A	MINOR AMENDMENT	16.04.19
REV	DESCRIPTION	DATE
PROJECT	BOGNOR REGIS BANDSTAND	
	THE ESPLANADE	
	BOGNOR REGIS	
	WEST SUSSEX	
DRAWING TITLE	PROPOSED ELEVATIONS, FLOOR PLAN AND ROOF PLAN

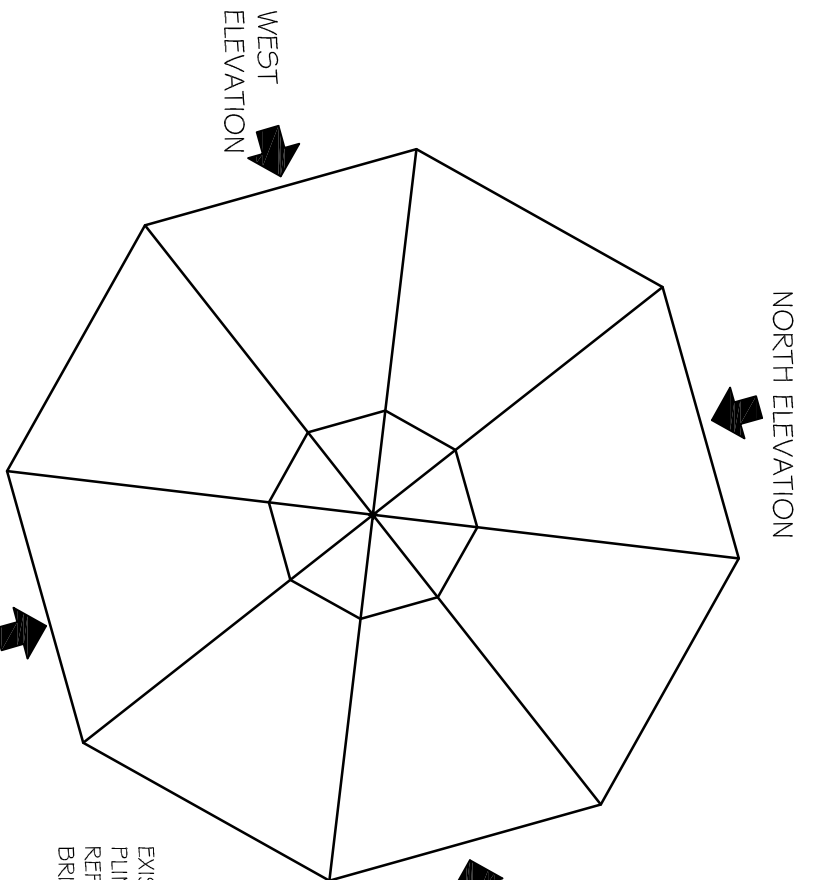
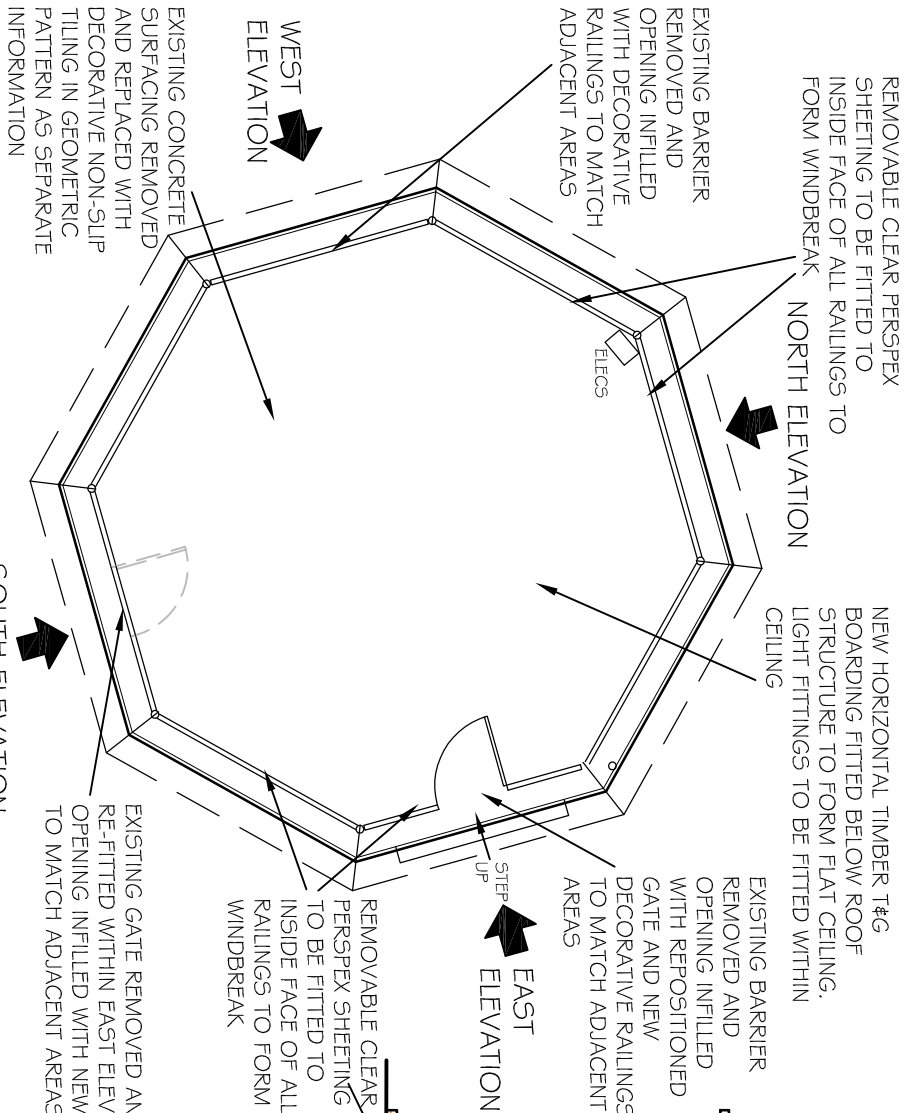
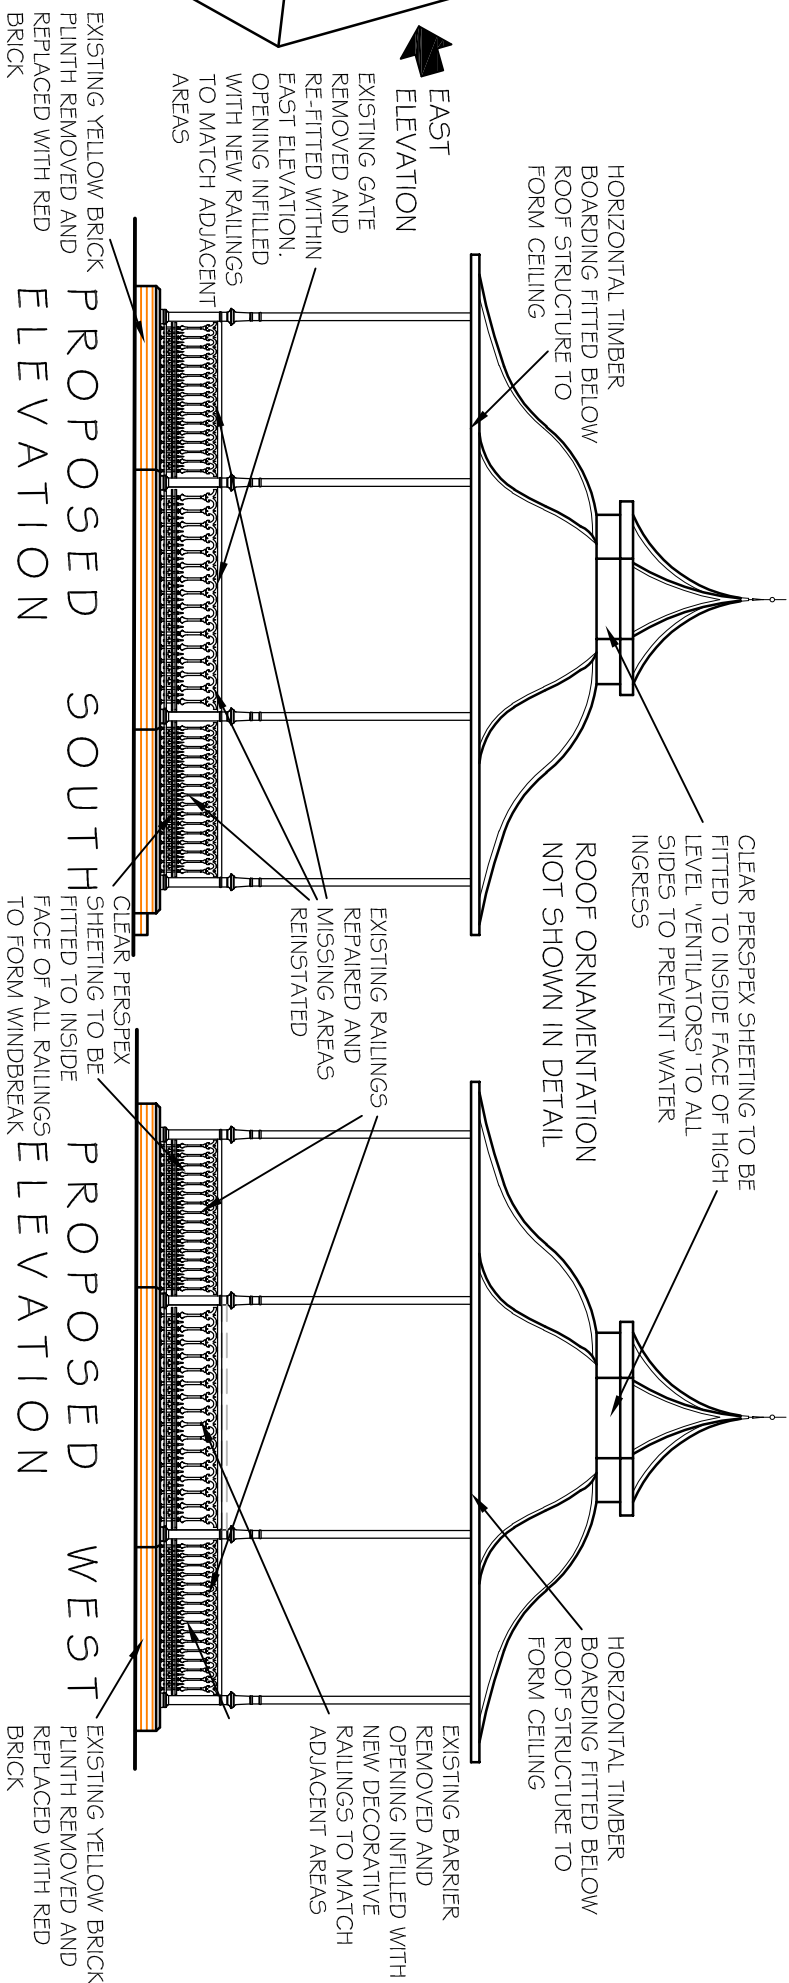
However, there are some issues which require clarification. It is not clear from reviewing the information why the location of the gate is to change.

Further, scant information has been provided regarding the proposed Perspex sheeting; how will it be fixed to the structure? Will it form a permanent element of the structure, or will it be used on a temporary basis (and removed when not required)? Further, what size will the panels be? What would the quality of the materials used be? At present, such an issue is considered to be problematic.

Please find attached drawing 824-04B which now omits the previously proposed Perspex sheeting to the railings which would have formed windbreaks.

I can confirm the proposed Perspex sheeting at high level has been retained within the proposals. This will be fitted on the inside face of the existing metal fretwork and is required to prevent water penetration into the structure. The new Perspex sheeting will not be readily visible and would be potentially easily removable on a future occasion in order that the work can be fully reversed.

- **Relocation of access gate.** The Bandstand has previously been disassembled and re-assembled and is not in its original location. There is no particular historic or architectural significance related to the current positioning of the access gate except that it faces directly onto the seafront. The balustrading and handrail (and associated access gate) are relatively interchangeable between the main structural support posts as the structure is a regular, symmetrical shape. The relocation of the gate will position it where there is currently an access step, which would seem an entirely logical location as this position would enable easy access and egress without disturbing the main thoroughfare along the promenade.

- **Perspex sheeting.** This will be secured on the internal face of the metal railing with simple ties of metal wiring. This will mean there would not be any fixing into the existing structure and will enable easy removal and re-fixing as required. It is anticipated that the sheeting will be in place on a relatively permanent basis to provide some protection from the weather from people seated within the bandstand. This sheeting will enable the bandstand to be used on a frequent basis as a viable use for a seating area. However, the sheeting could be fairly quickly and easily removed and replaced as required due to the simple nature of the fixings. The panels will be clear, frameless panels fitted to a height just below the handrail and would fully fill the width between each of the main structural posts. The structure including the metal railings will be clearly visible through the proposed panels, and accordingly there would not be any negative impact on the visual qualities of the structure. When The Bandstand was in its original location in Cheltenham it was fitted with glass panels (as noted in the Heritage Statement) but these were not re-fitted when it was relocated to Bognor Regis. We trust this information will also help to satisfy the concerns raised by the Town Council.
